Application No: BN/14/22/PL
Site Address: Land rear of Cedar End Eastergate Lane Eastergate PO20 3SJ
Description of works: 1 No. 5 bed detached bungalow with new vehicular access. This application is within CIL Zone 3 and is CIL liable as new dwelling. This application is a Departure from the Development Plan.

Thank you for your internet representation made on 11th March 2022 which has been recorded as an objection with the comments as follows:

The documentation supporting this planning application is inaccurate in some aspects and requires clarification of the following issues.

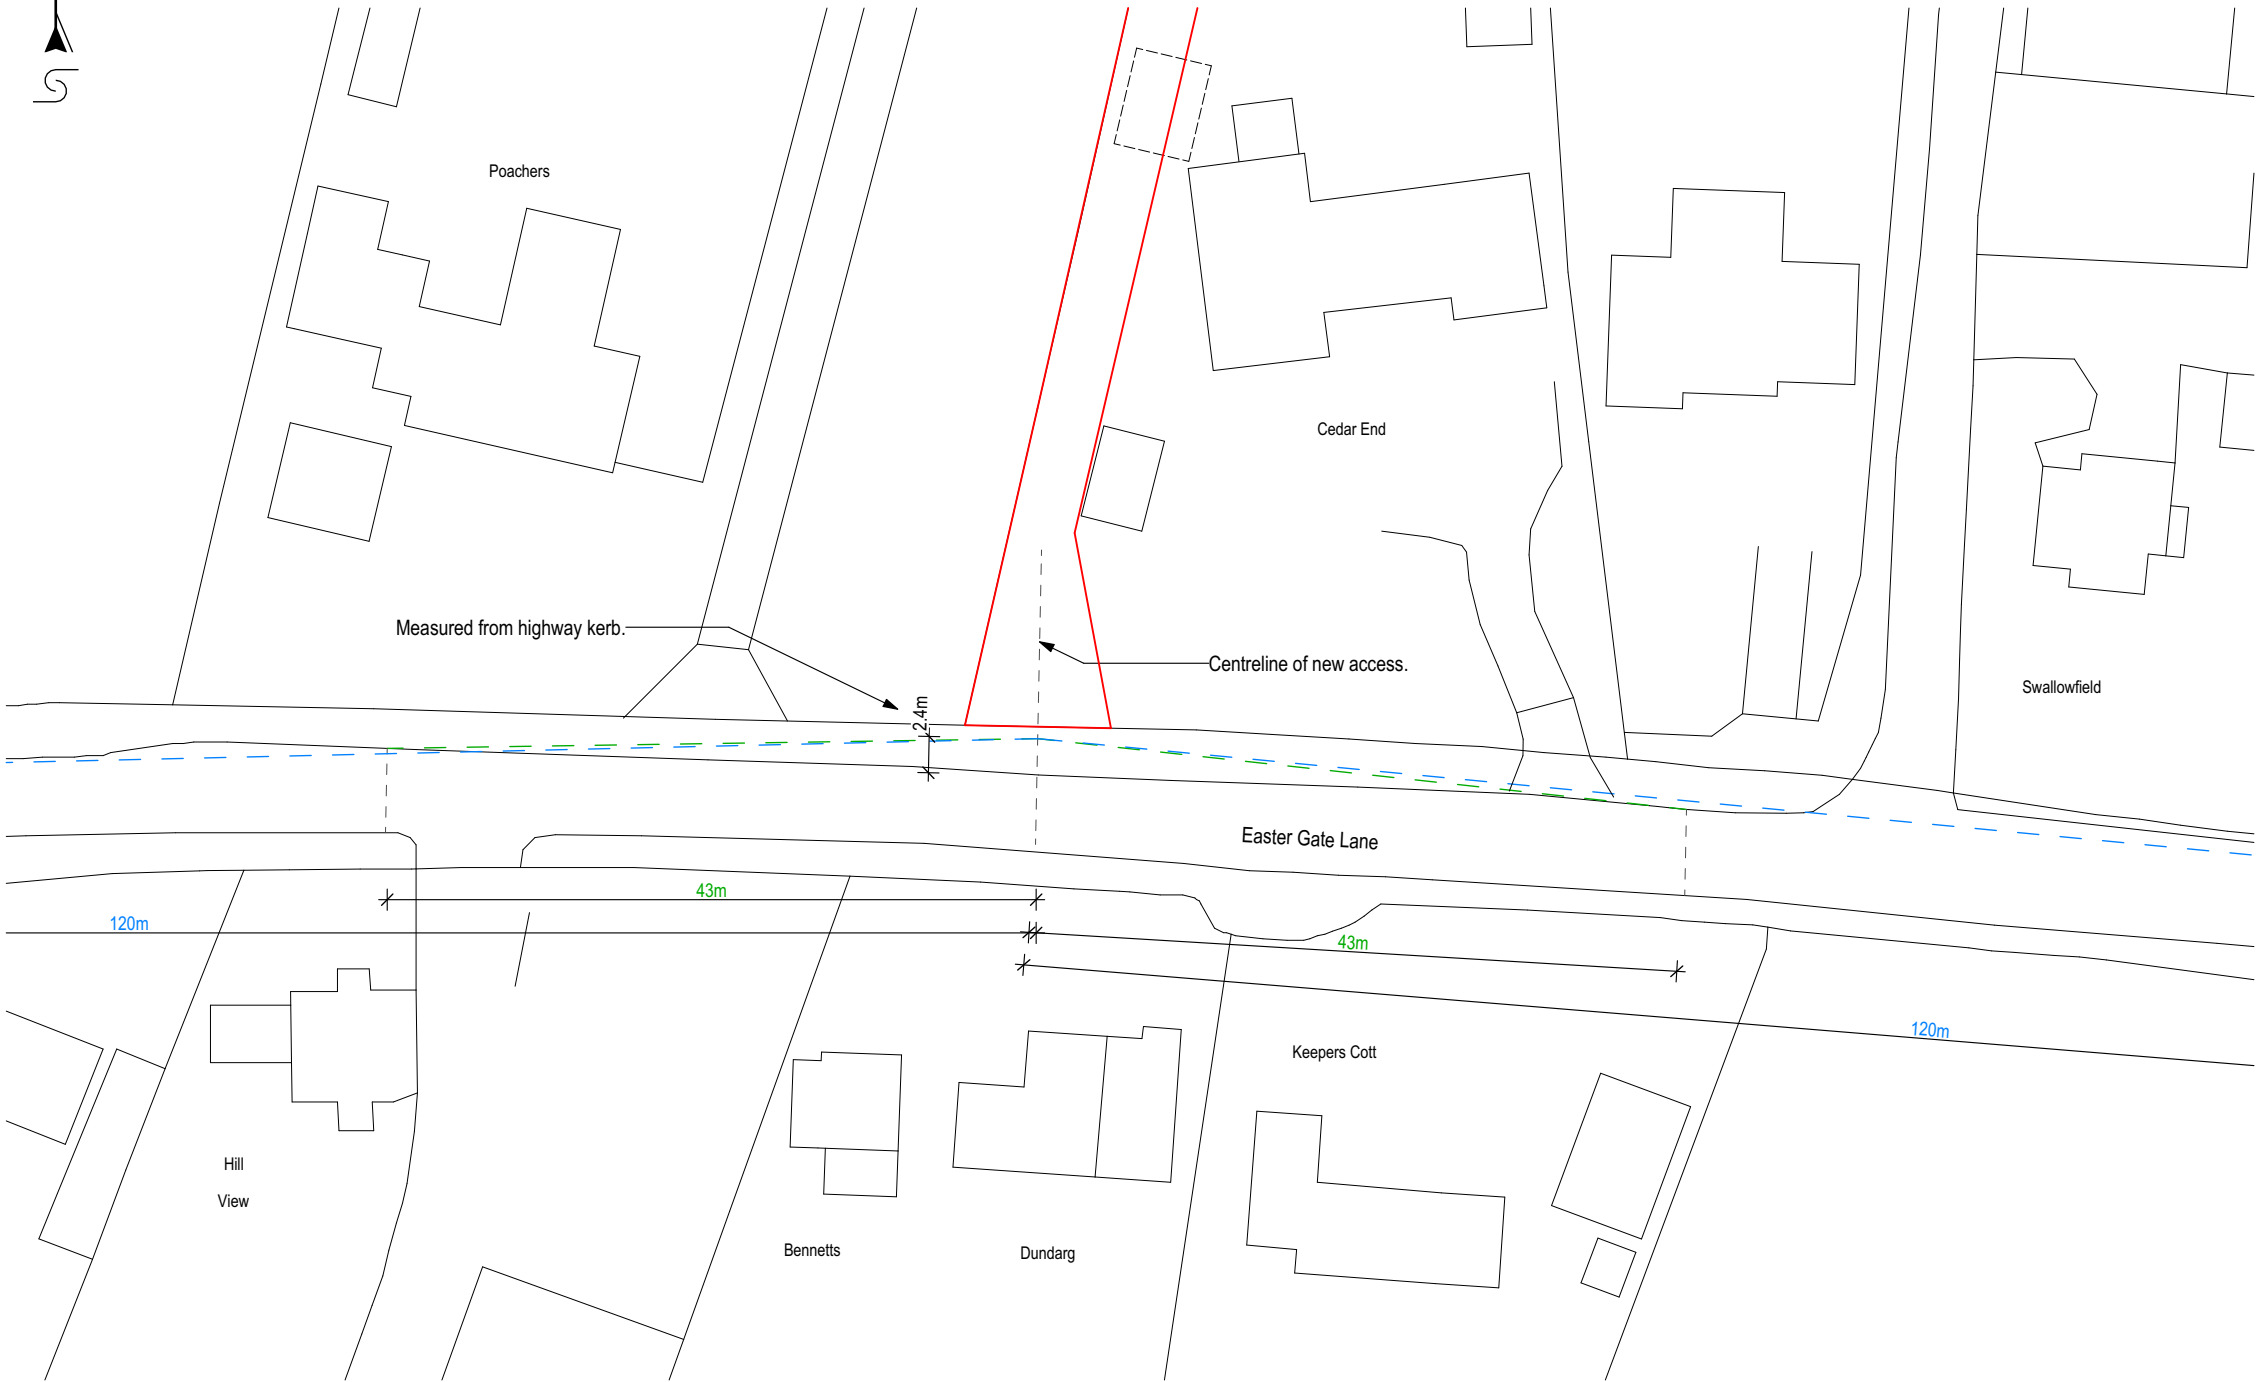
The visibility splay drawing No 1671-SYM-00-ZZ-DR-A-0209-PO1 overlies the OS map and not the land survey and does not show all relevant features.

A revised visibility drawing needs to be produced overlying the land survey rather than the OS plan for accuracy, with Bennetts, Dundarg and Keeper's Cottage entrances accurately indicated so that any impact on these existing accesses can be properly assessed.

Also dimensions need to be provided for the entrance layout as it is difficult to measure from an A4 printout, again so the impact on neighbouring properties can be fully assessed.
